The Member Secretary,  
Chennai Metropolitan  
Development Authority,  
No.1, Gandhi Irwin Road,  
CHENNAI -600 008.

Letter No. **A2/16242/2003**

Sub: CMDA - **Planning Permission - Construction of GF+1F with 3 dwelling units of Residential Building at Plot No.331, S.No.343/1, Asthalakshmi Nagar, Maduravoyal Village - Development Charge and other charges to be remitted - Regarding.**

ELEVATION OF COMPOUND WALL

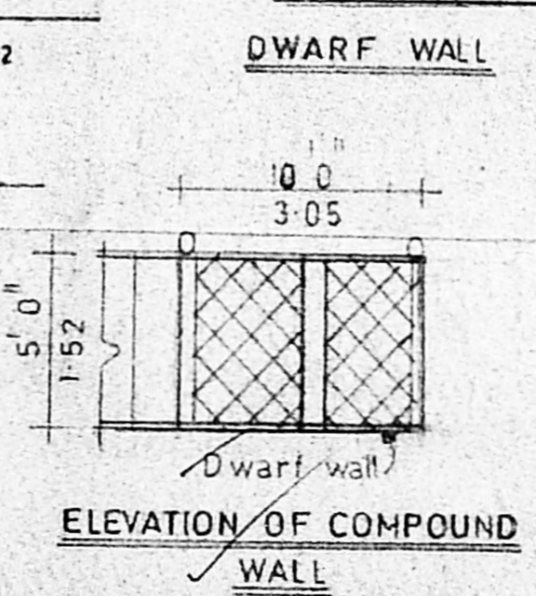
- a) Rain water conservation regulations stipulated by CMDA should be adhered to strictly.
- b) 5 copies of revised plan by
  - 1) Showing the compound wall details with section and elevation and 7.50cms height of dwarf wall along the gate.
